# V11\_GEC Plans.pdf Markup Summary

**Subject:** Callout  
**Page Label:** [1] 8 GRADING & EROSION CONTROL PLAN  
**Author:** CDurham  
**Date:** 2/15/2024 11:48:31 AM  
**Status:**  
**Color:** ■  
**Layer:**  
**Space:**

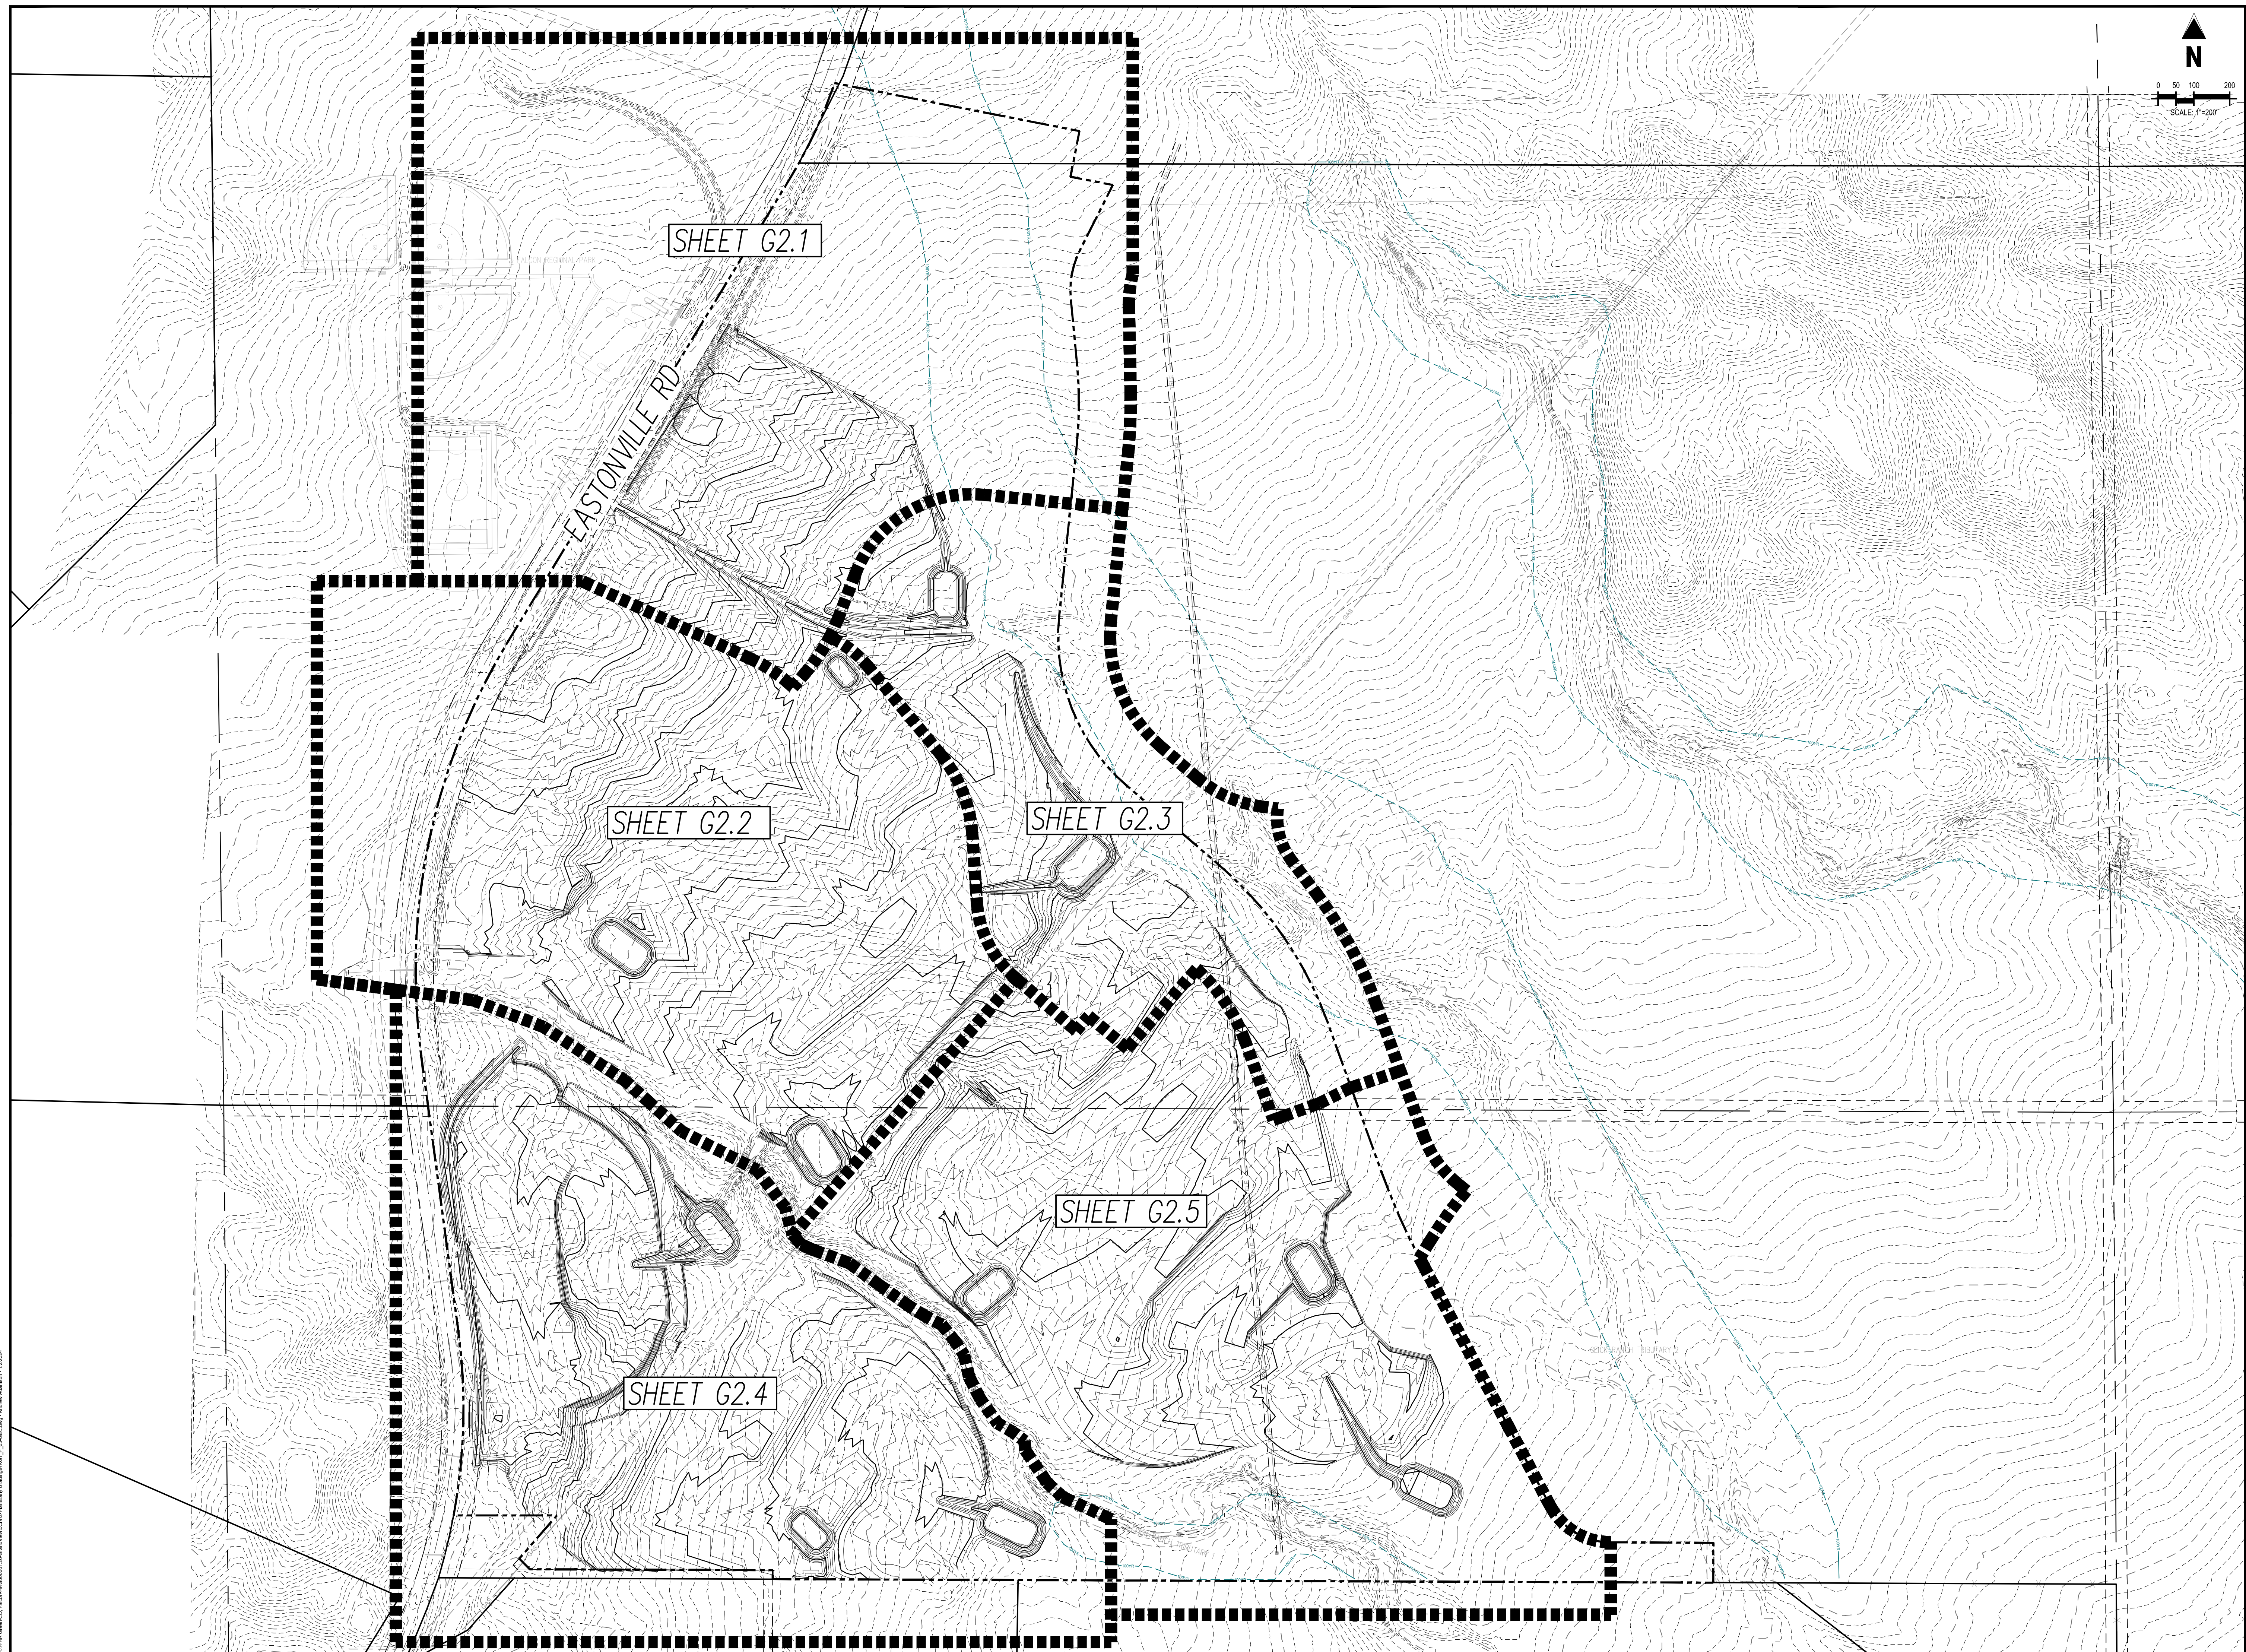
Why is the swale not in line with the culvert? How will culvert flows be conveyed to the swale?

**EARLY GRADING & EROSION CONTROL PLANS**  
**GRANDVIEW RESERVE FILING NO. 1**  
 FOR  
**HR GREEN**  
 EASTONVILLE RD  
 EL PASO COUNTY, PEYTON, CO 80831

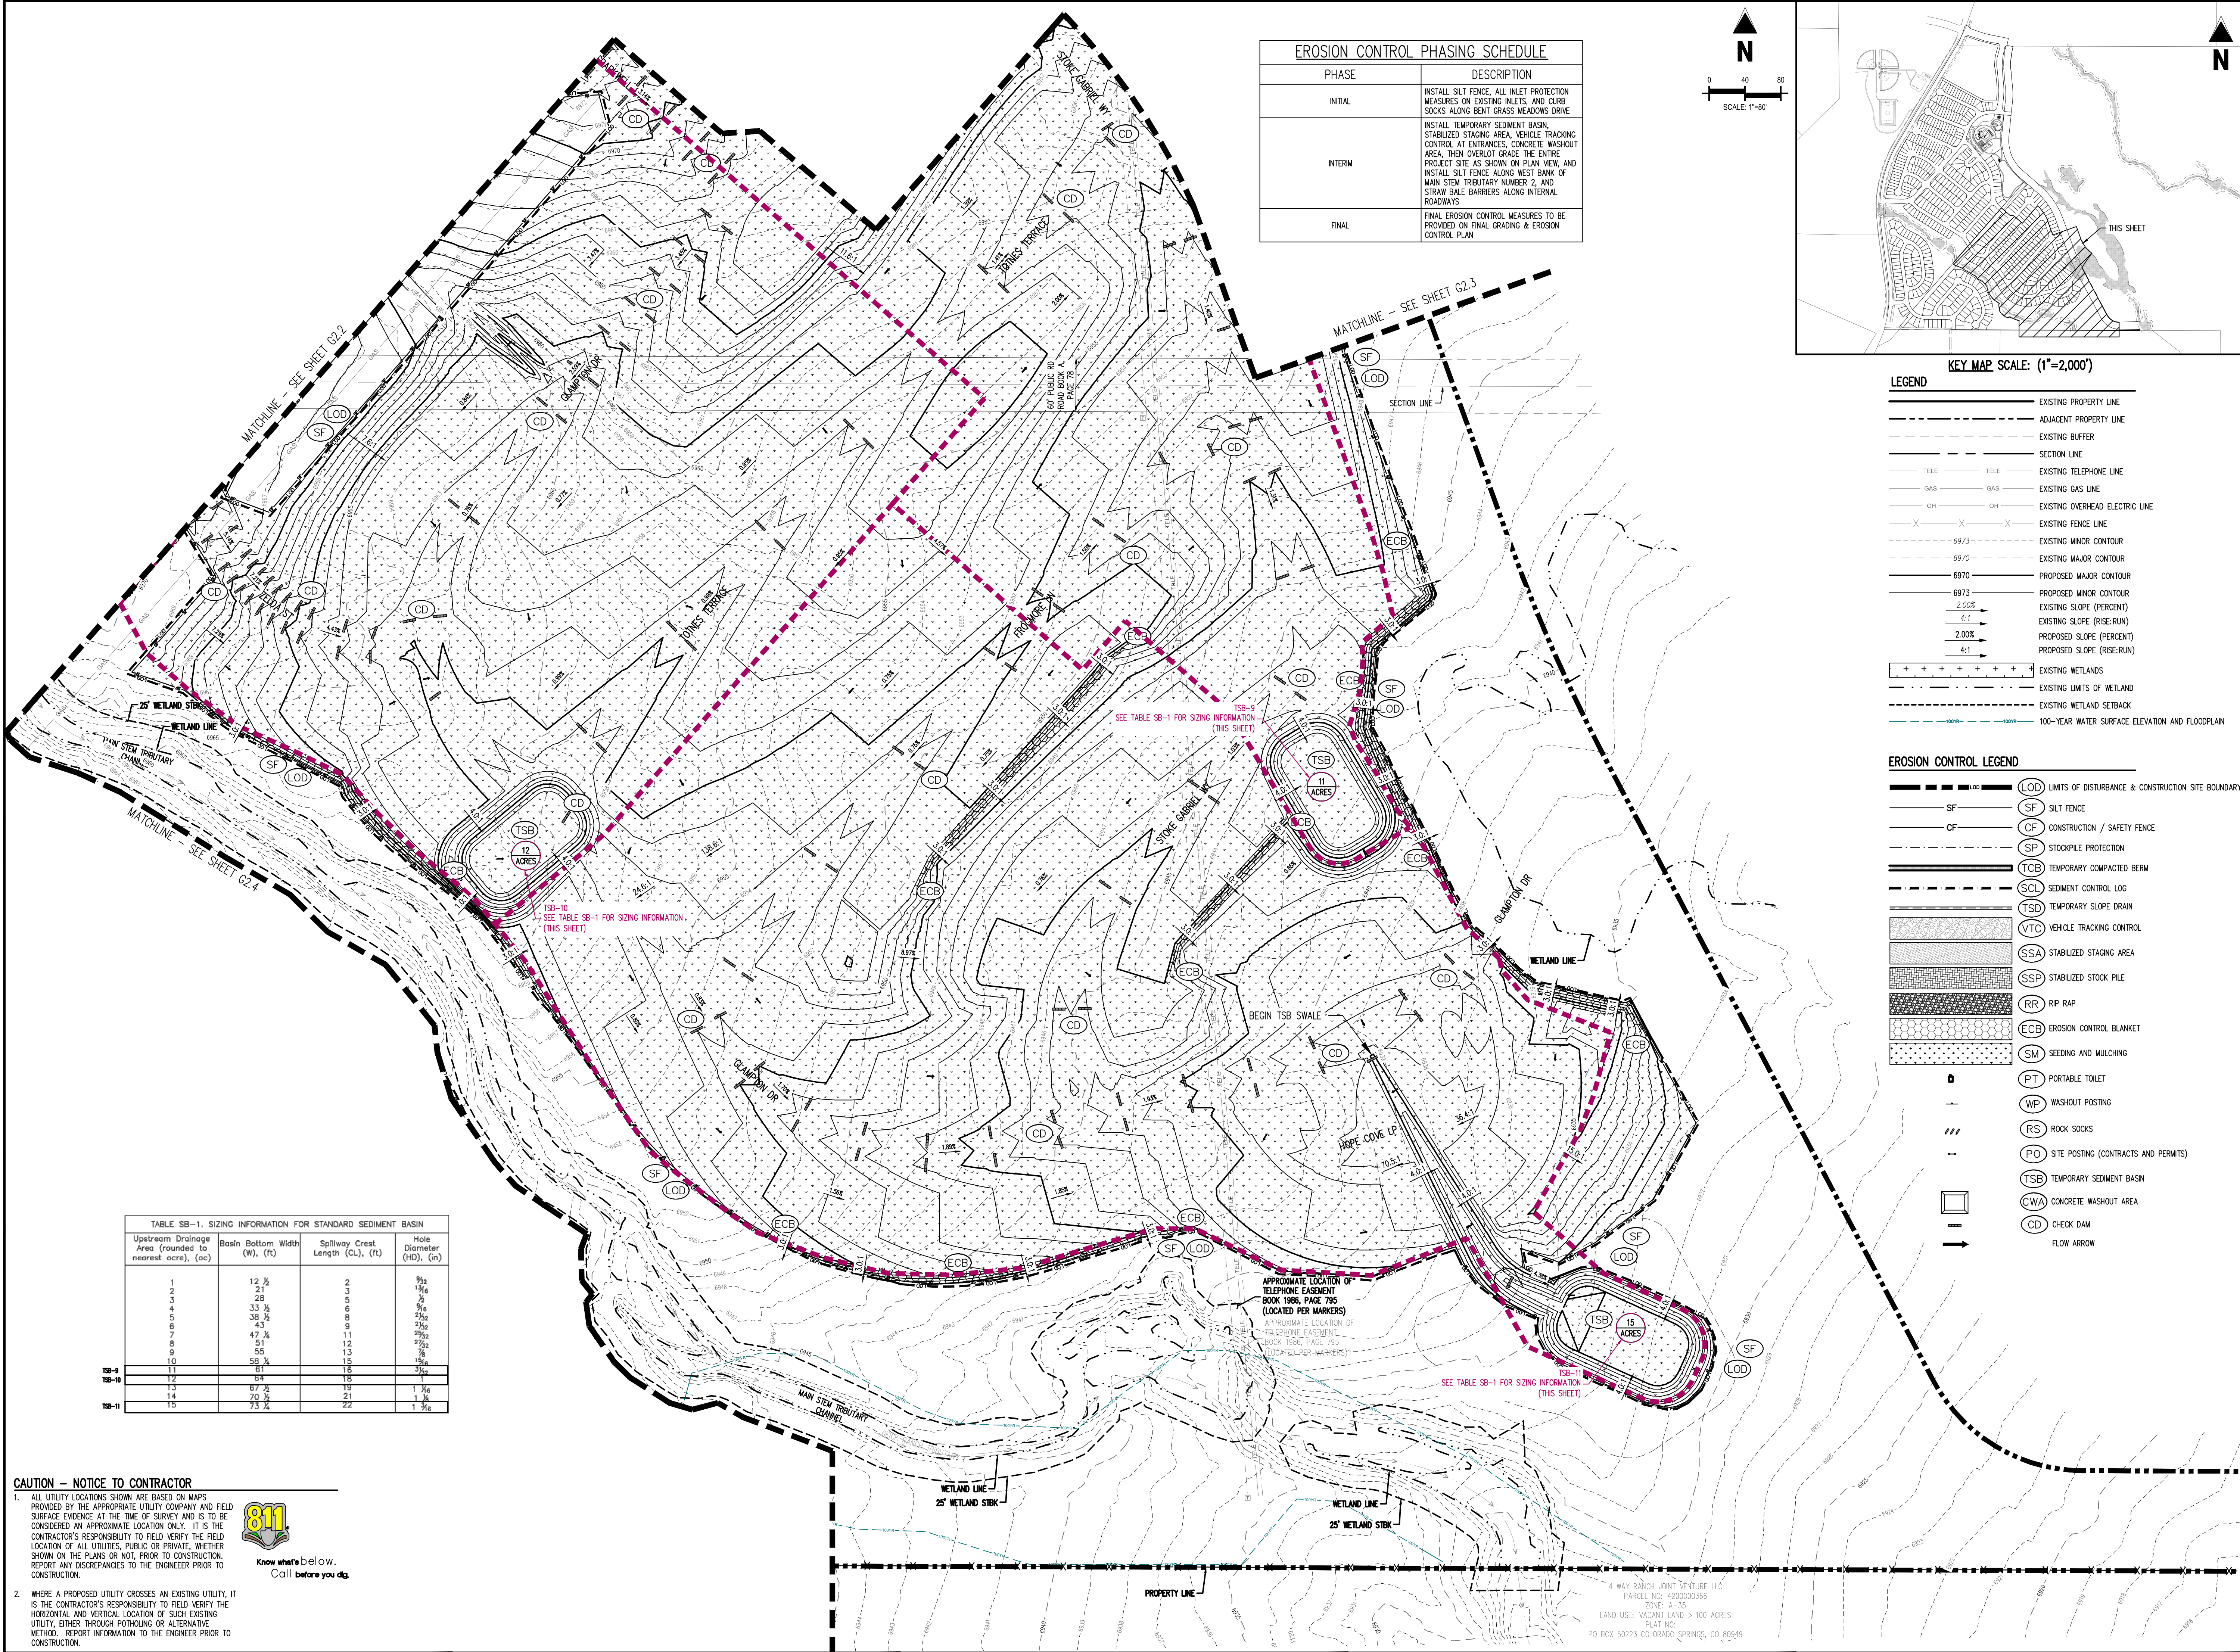
Silt fence can not be used to direct flows.  
Reconsider location or type of BMP needed here.

Riprap is shown in this swale on Sht G2.1 but not on this plan. Revise to remove discrepancy and to provide adequate erosion protection.

Consider need for riprap apron here or other means of outfall protection. Silt fence is not a suitable temp BMP for the outfall of a swale.
